Permit Number: 030848

Proposed Project Description:
 Amendment to permit # 021103 to change garage door to 10' x 16'.

30 Luke st Amendment

JAMES RUSSO GARAGE 32' X 32'
30 LUKE ST ON INSULATED FLOATING
PORTLAND ME SLAB

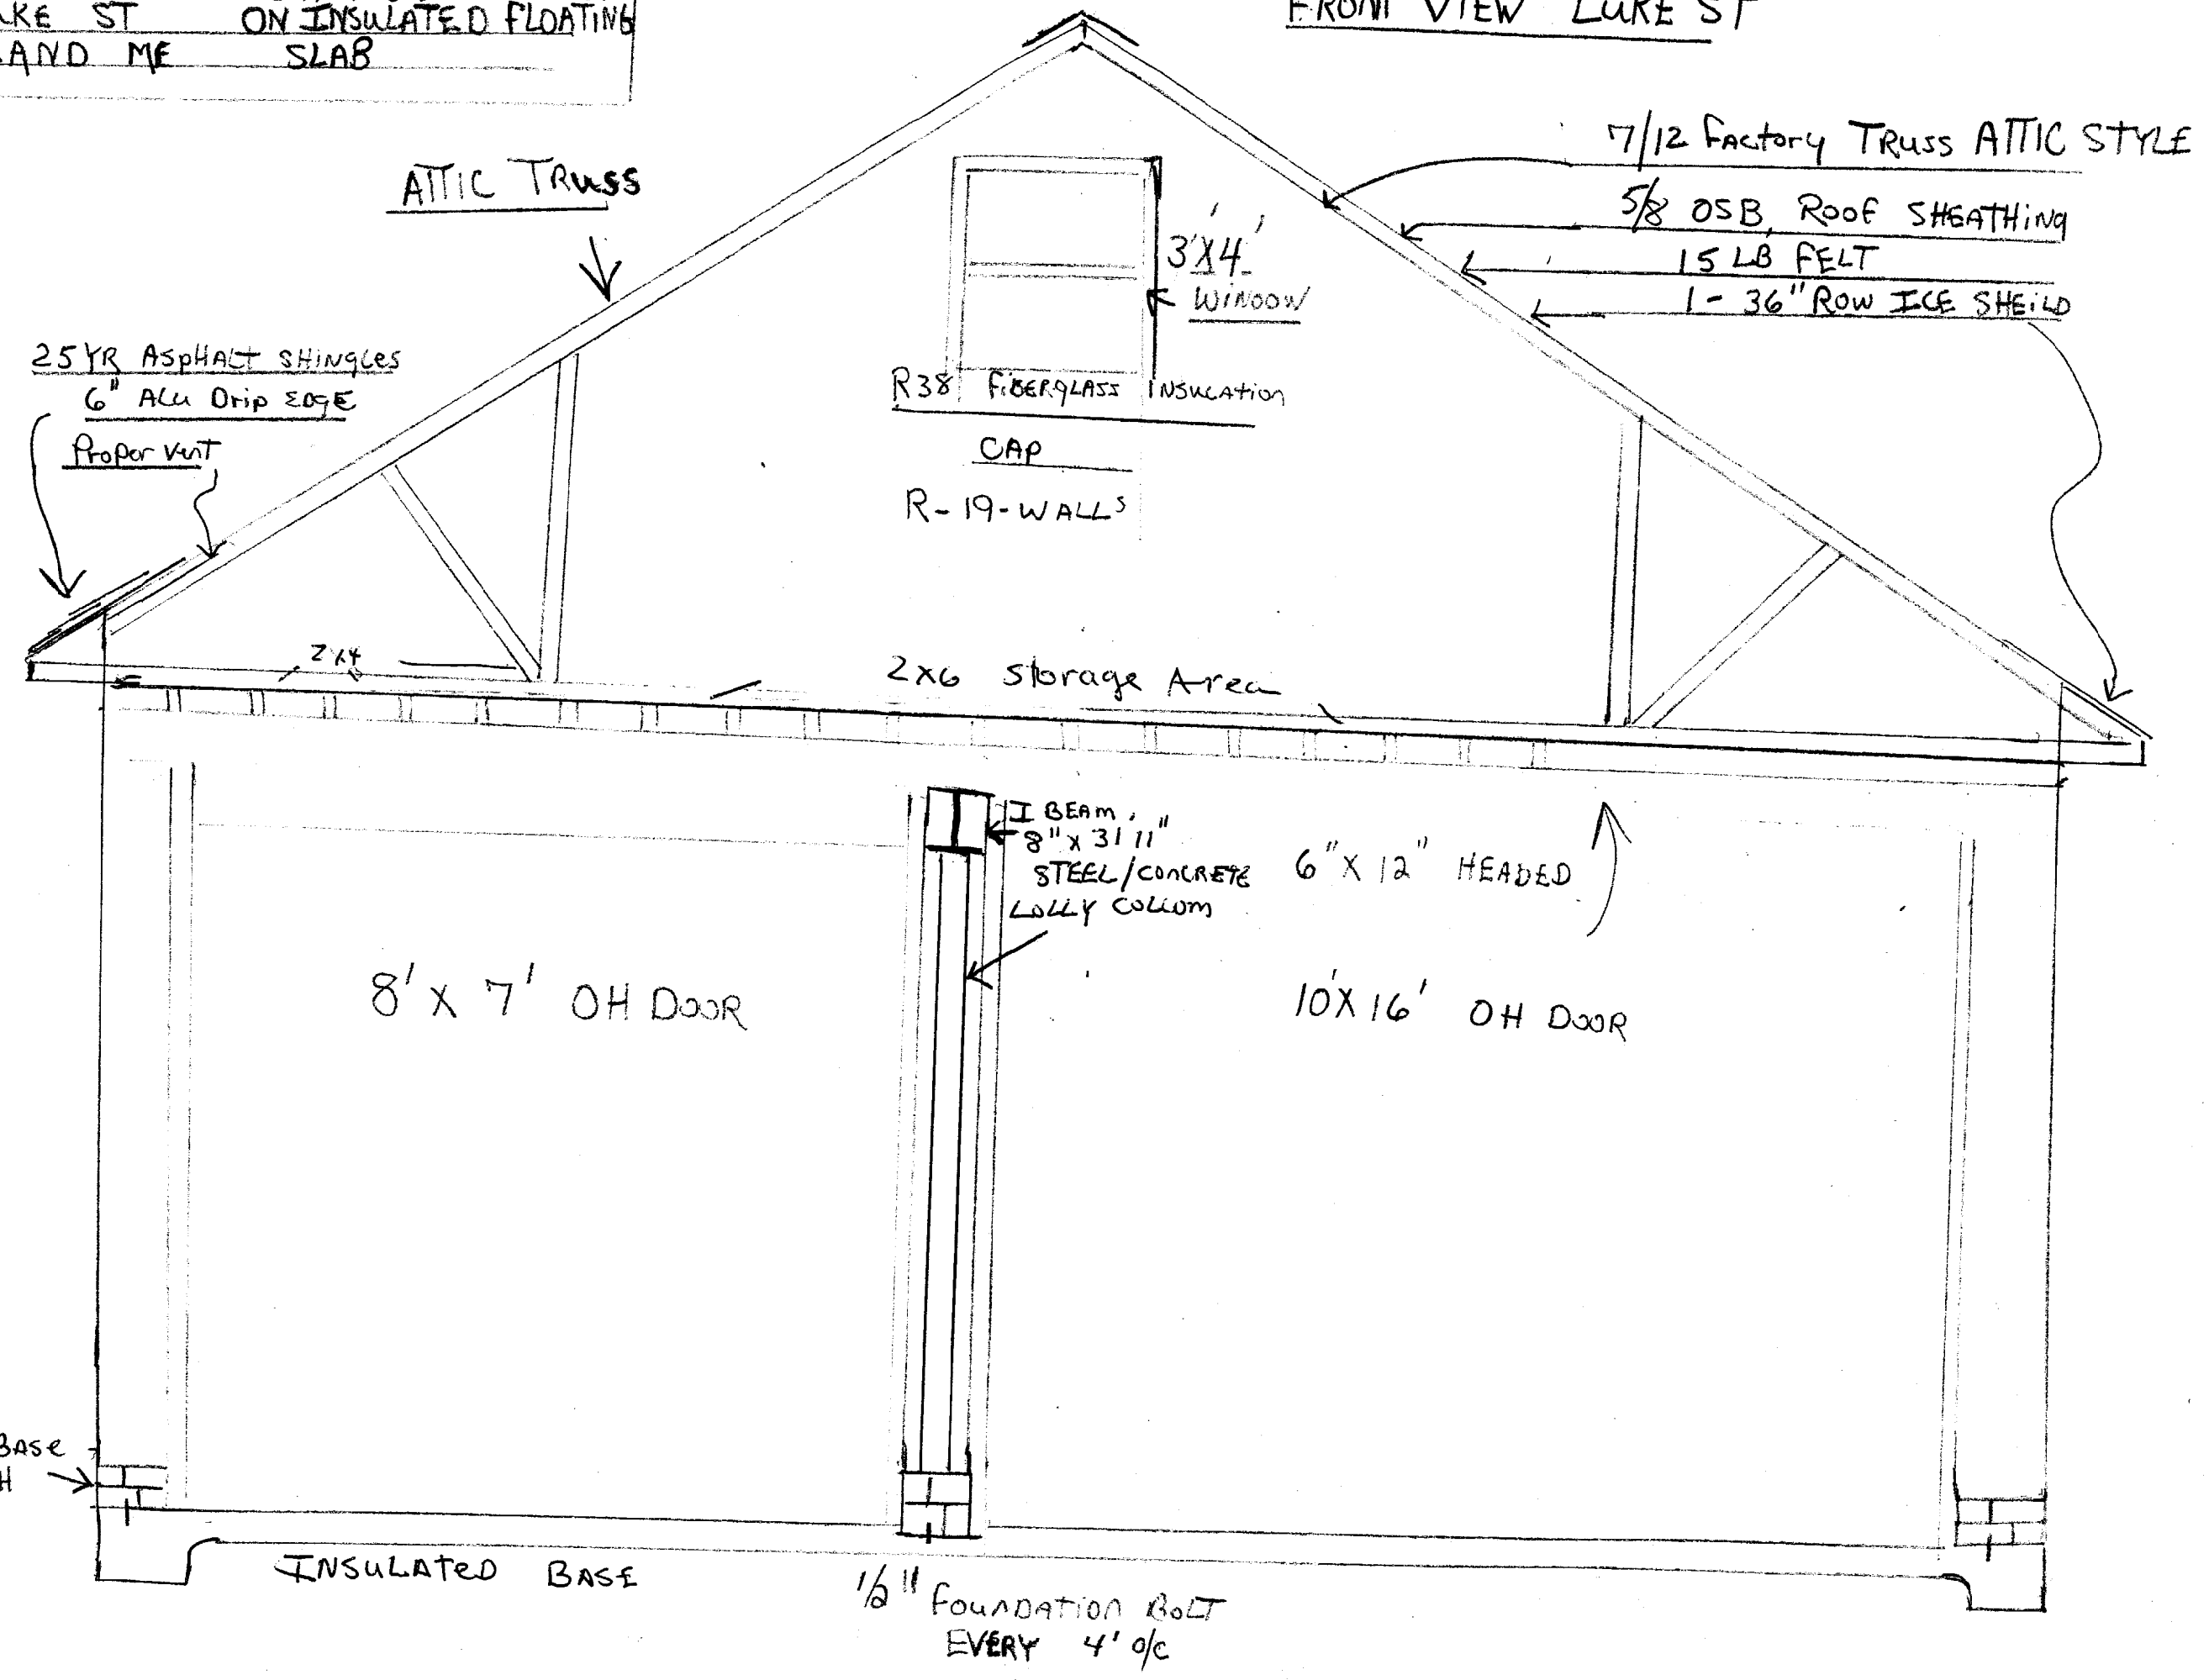
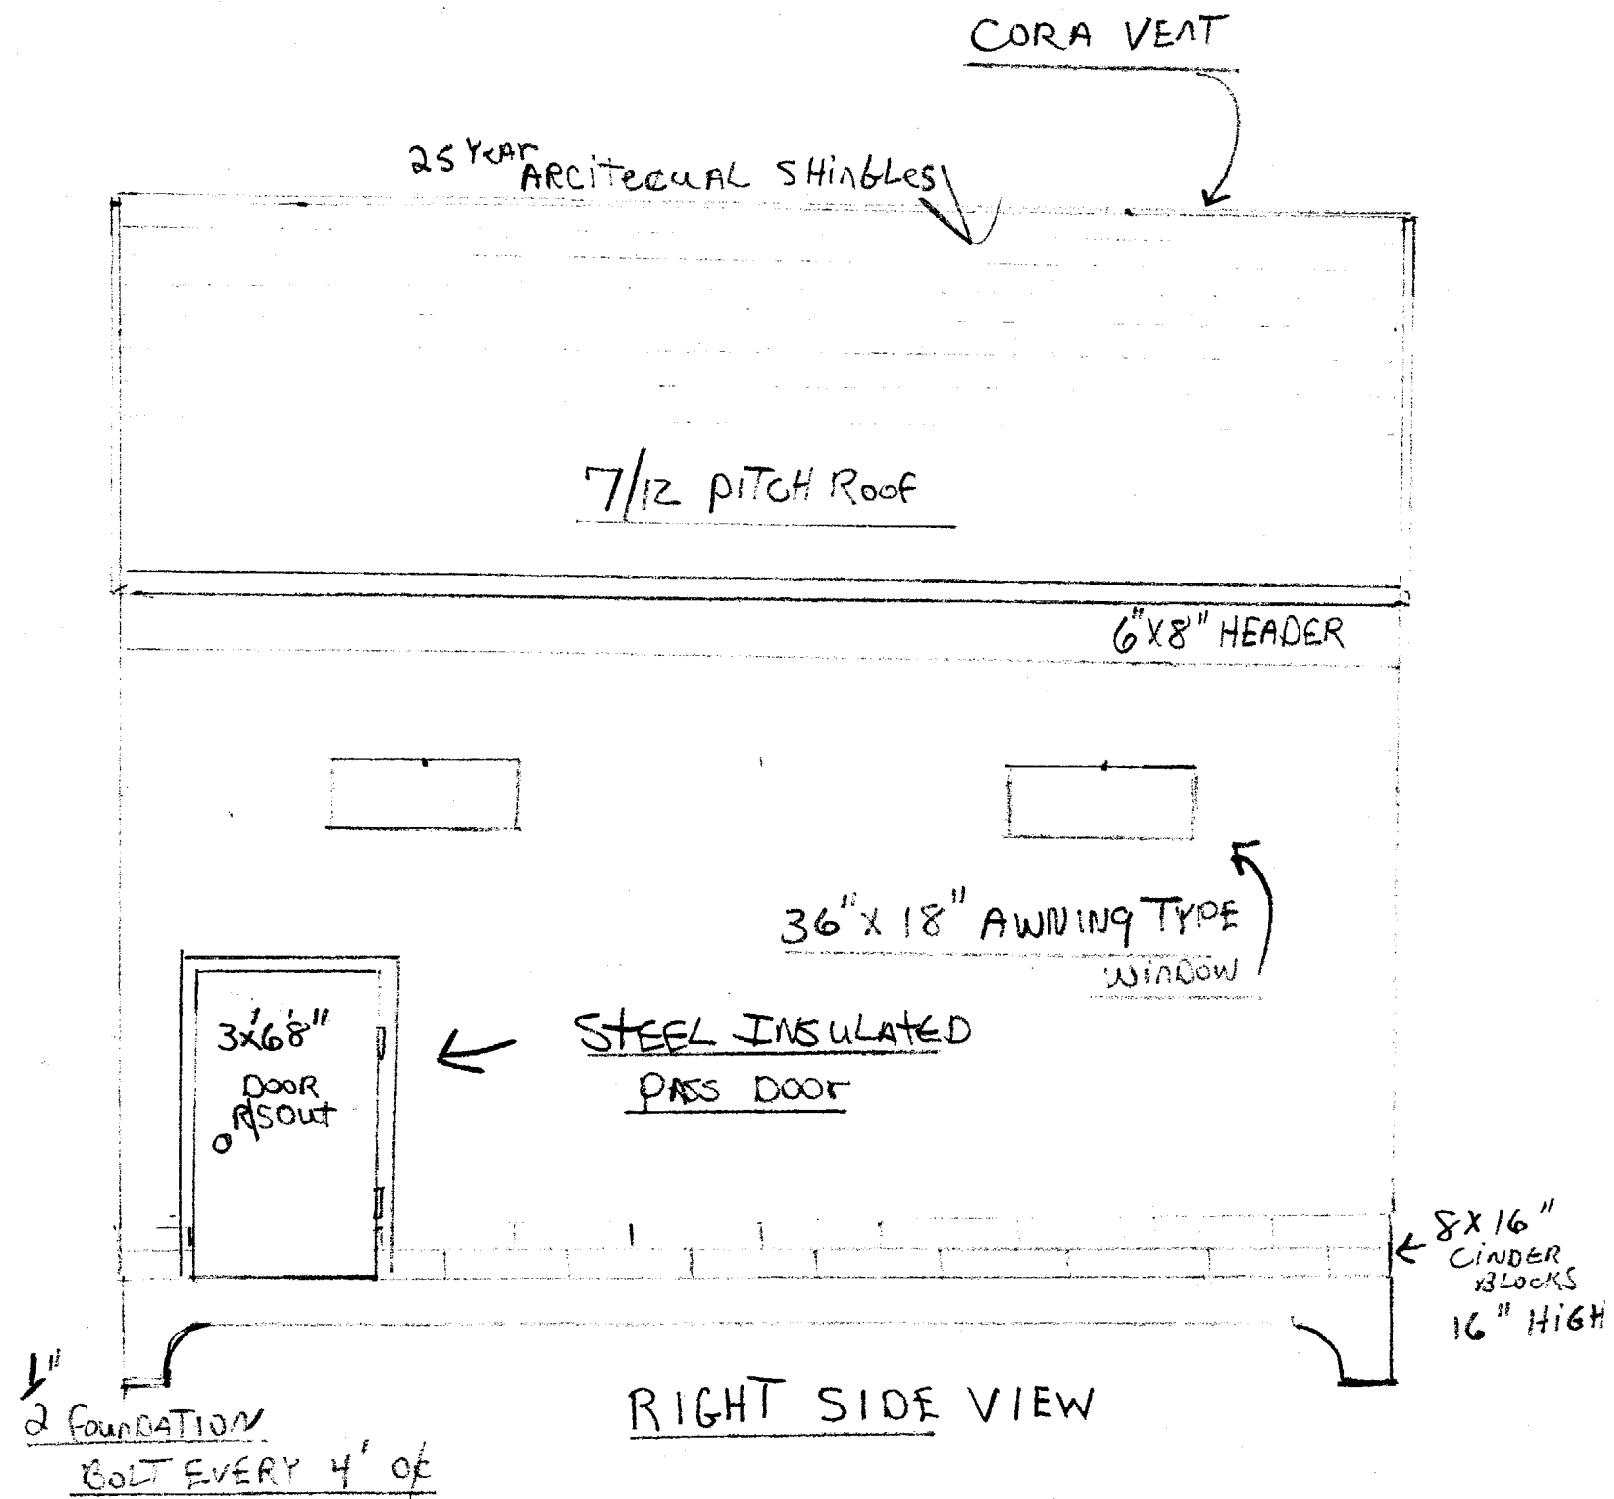
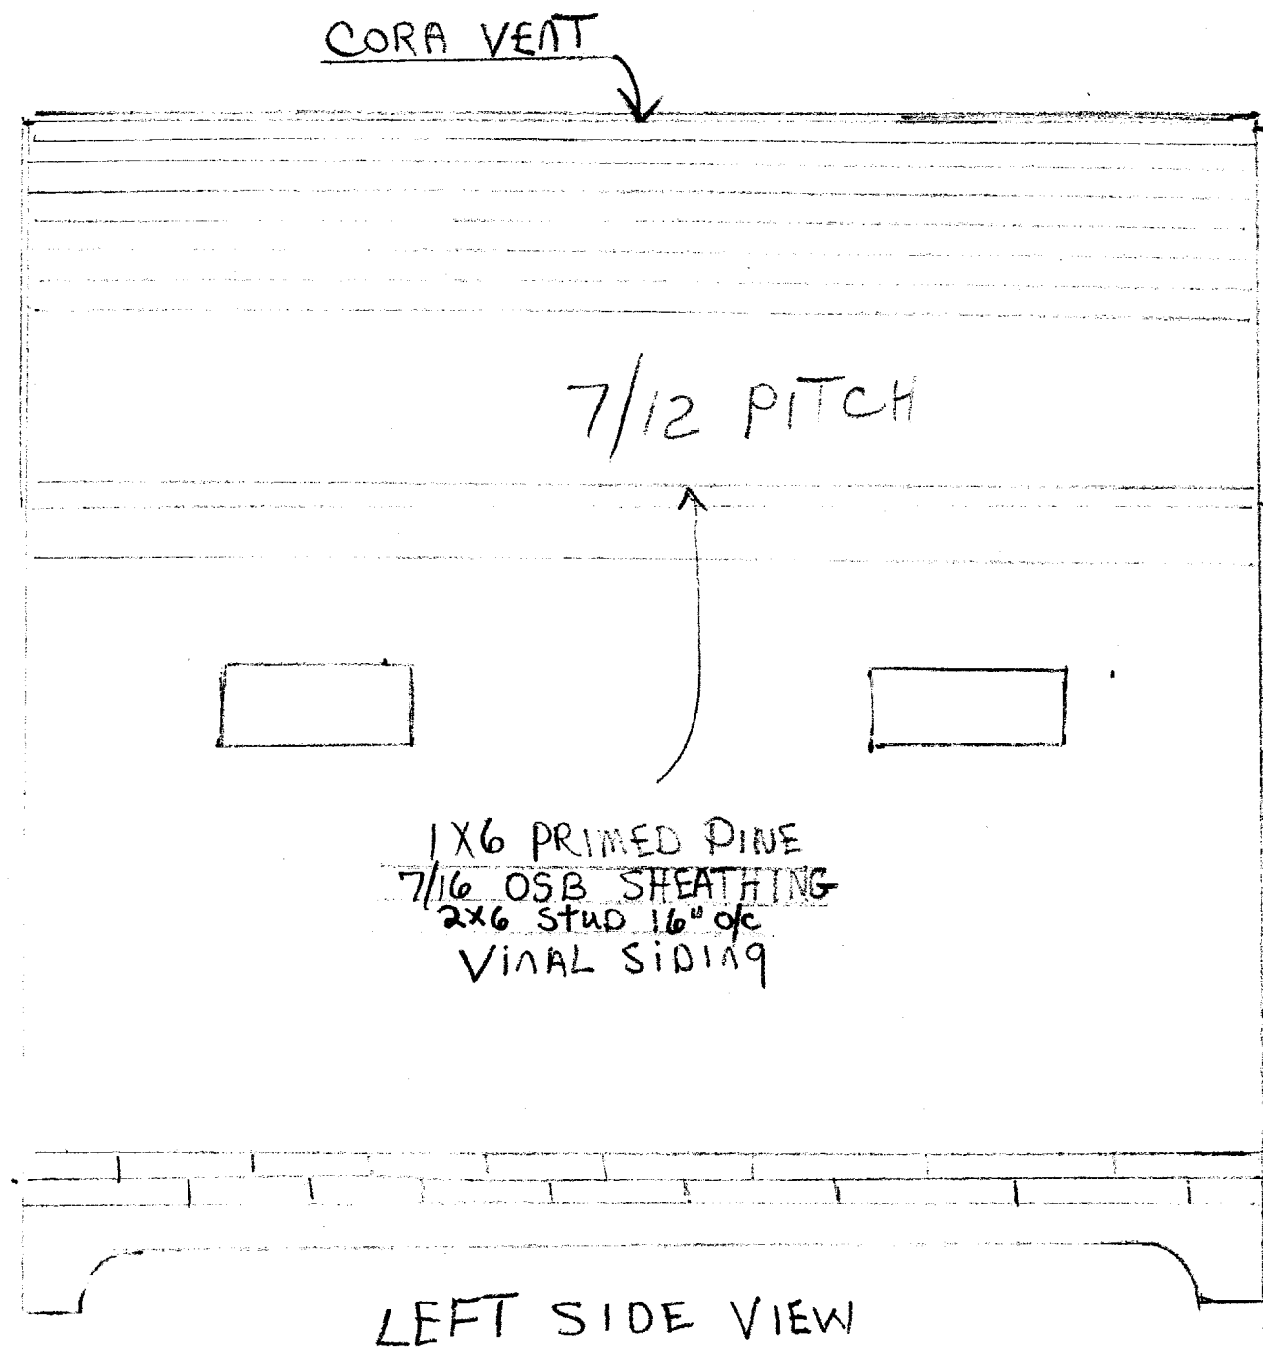
Installed entrance
Door in front
Not on the
side
Did not install

9' x 8' Garage
Door in front
Just one
10' x 16'
